TO: Kaycee Hathaway, CDS  
FROM: Christina Wollman, Planner III *CW*  
DATE: April 25, 2014  
SUBJECT: Kittitas County Fire District #6 PF-14-00001

The Department of Public Works has reviewed the Public Facilities Permit for Fire District #6 and has the following comments:

GRADING PLAN
 KITTITAS FIRE PROTECTION DISTRICT #6
 RONALD, WASHINGTON

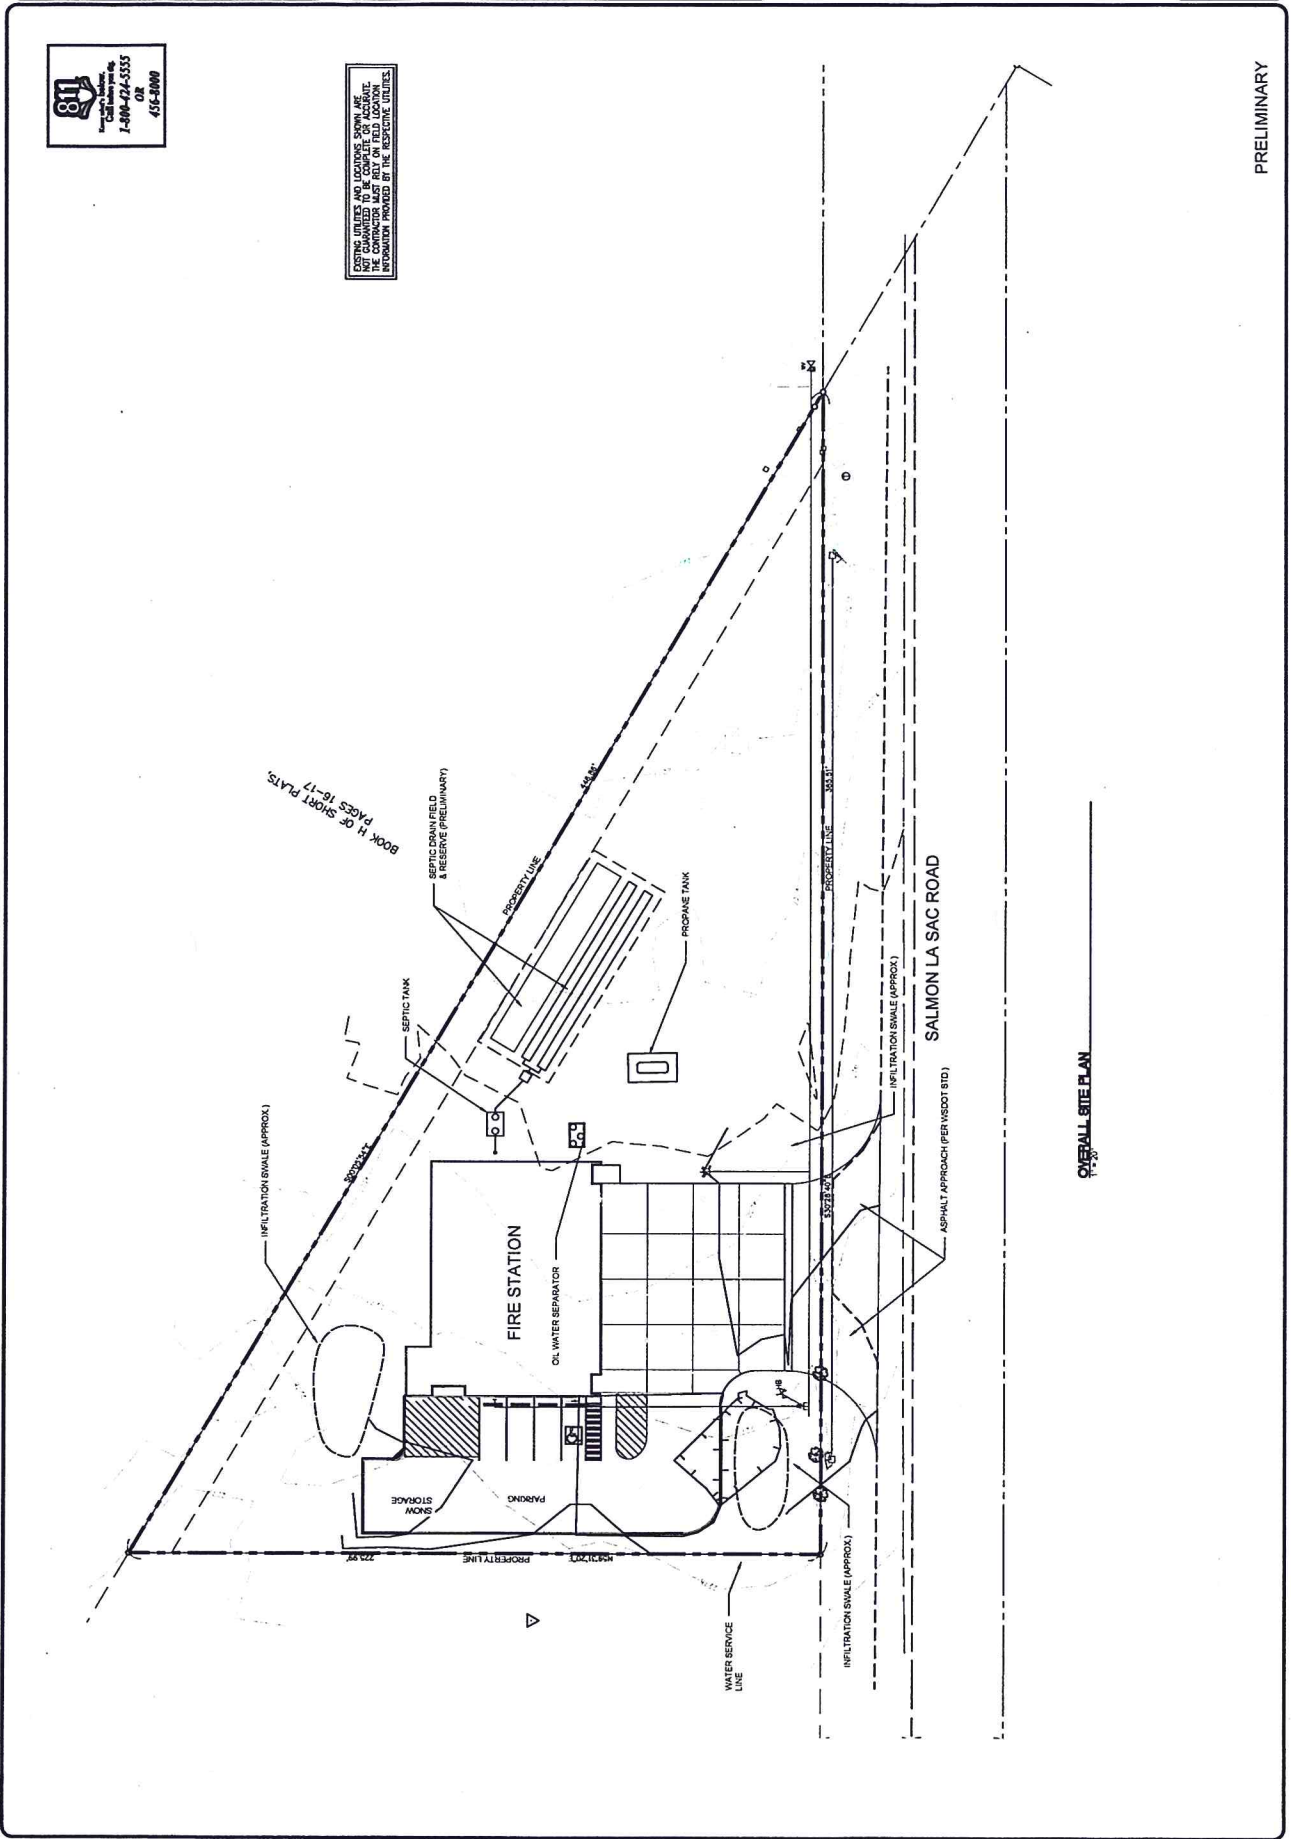
- B. Stormwater: On-site stormwater management that conforms to the specifications of the most current version of the Stormwater Management Manual for Eastern Washington is required of this development. Stormwater systems shall be designed to store stormwater generated by a 24-hour, 25-year storm event. Stormwater system designs shall be prepared and stamped by a civil engineer licensed in the State of Washington. The stormwater system design shall be presented to Public Works and reviewed by the County Engineer prior to issuance of a building permit. The stormwater system construction shall be certified by a licensed engineer prior to issuance of an occupancy permit.

OVERALL SITE PLAN

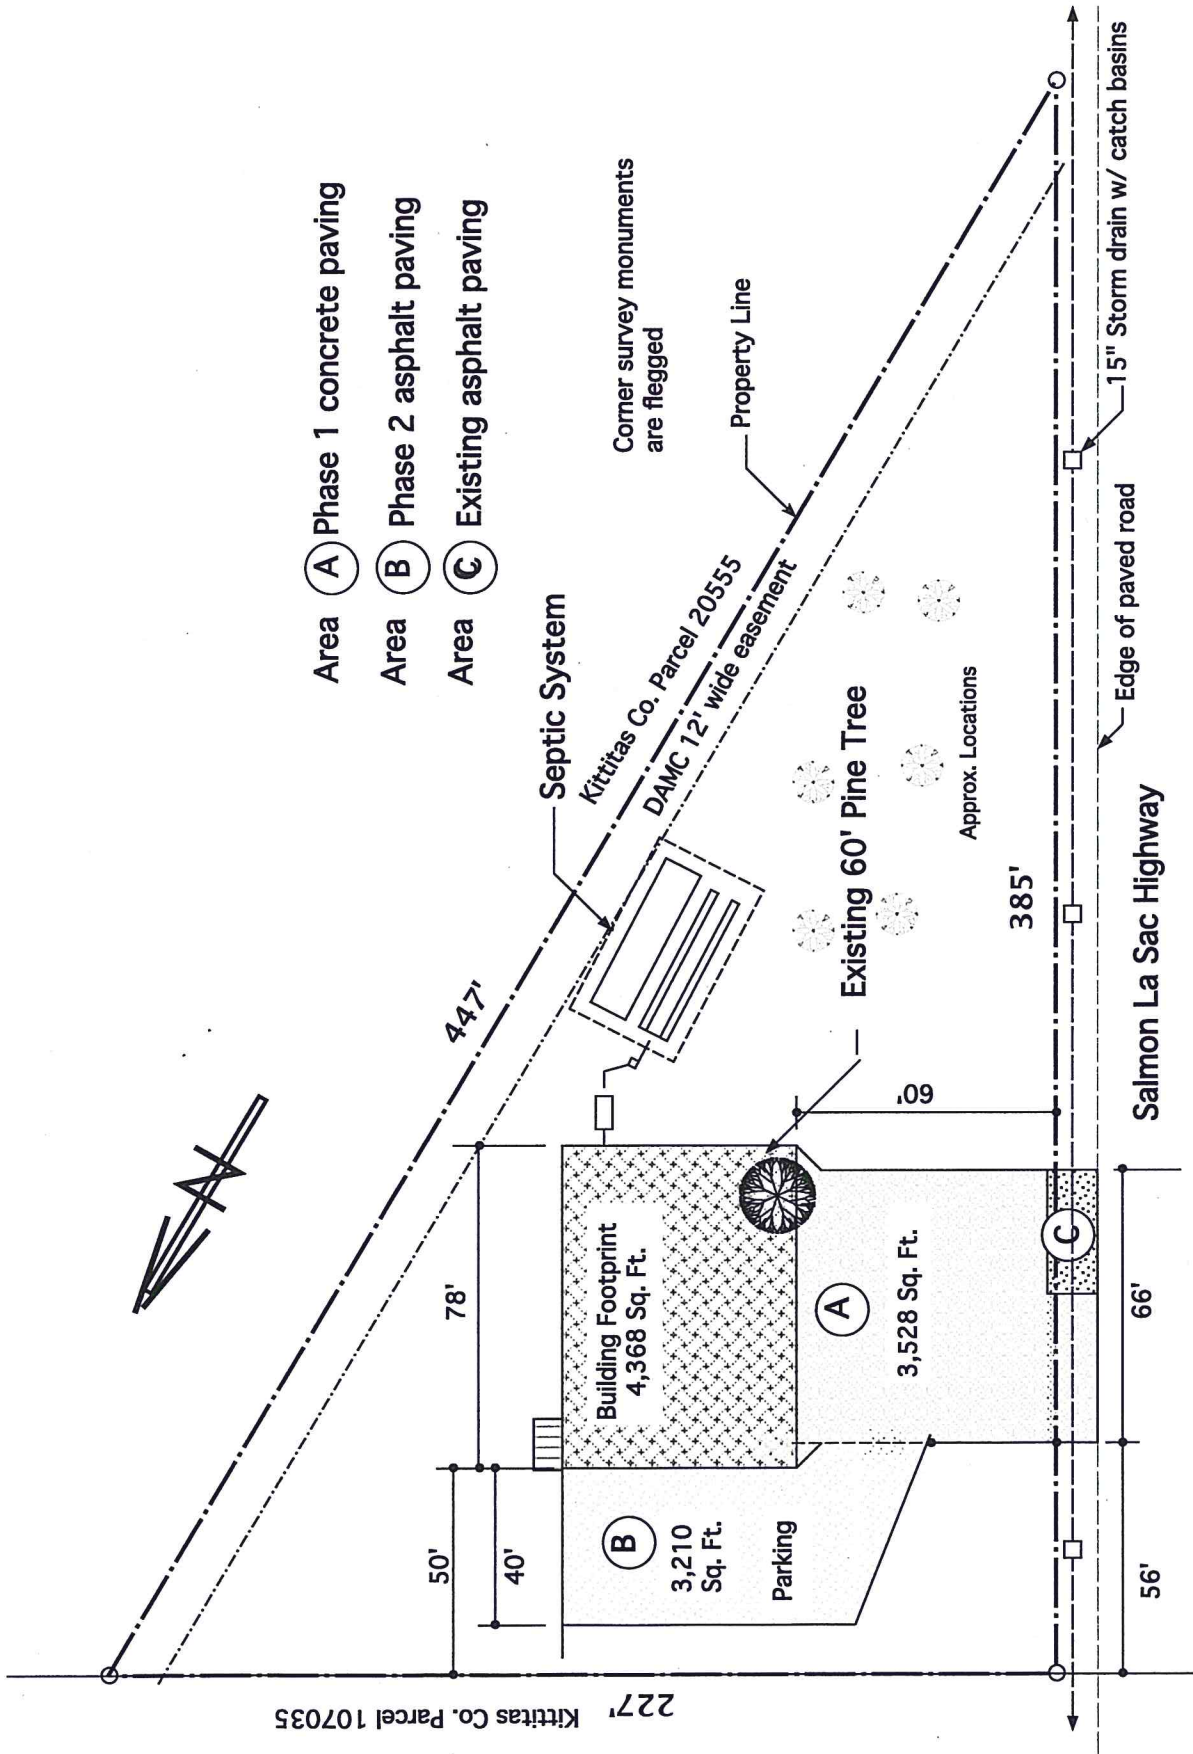
- A. Access: Access to the proposed Fire Station shall be constructed as required by Kittitas County Road Standards, which requires the access to be constructed to commercial standards. The access shall be constructed prior to issuance of an occupancy permit

- C. Access Permit: An approved access permit will be required from the Department of Public Works prior to creating any new driveway access or performing work within the county road right of way.
